WEST SUSSEX COUNTY COUNCIL CONSULTATION

TO:	Arun District Council FAO: Kathryn Welch
FROM:	WSCC - Highways Authority
DATE:	14 March 2022
LOCATION:	Land Fronting 15 and 31 Sea Road, East Preston
SUBJECT:	EP/14/22/PL Erection of Village Clock. This application is in CIL Zone 4 and is not CIL liable as other development.
DATE OF SITE VISIT:	N/A
RECOMMENDATION:	Advice
S106 CONTRIBUTION TOTAL:	N/A

Block Plan
1:500

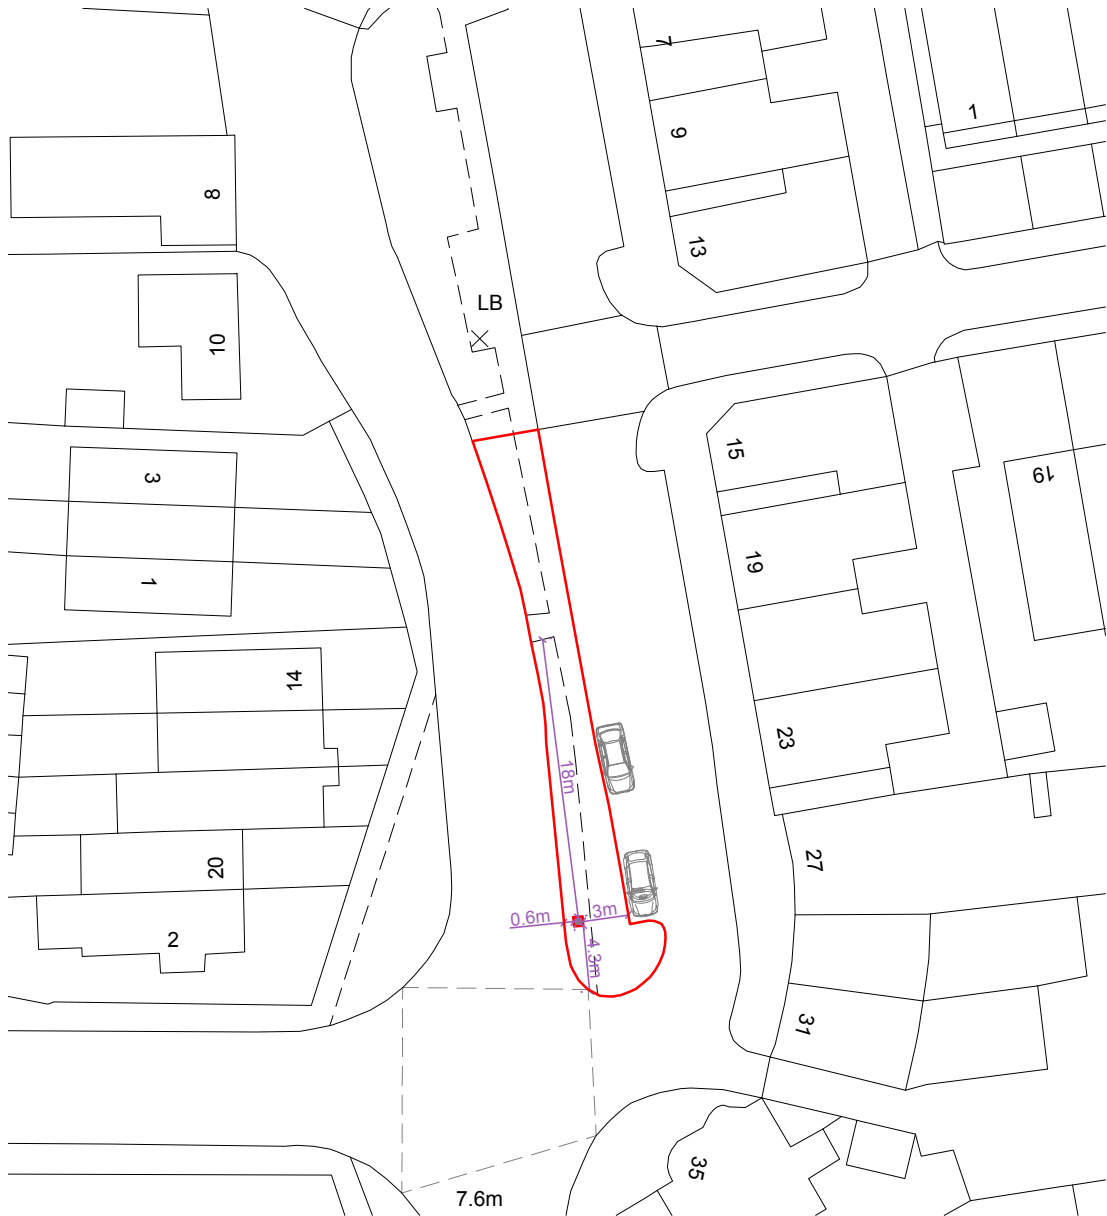
On review of the plans and local mapping, the proposed clock is not anticipated to obstruct vehicular visibility for those using the junction on Sea Road, nor obstruct the free flow of movements in this location. It is advised that the clock faces are clear and readily legible to minimise the possibility of passing road user distraction.
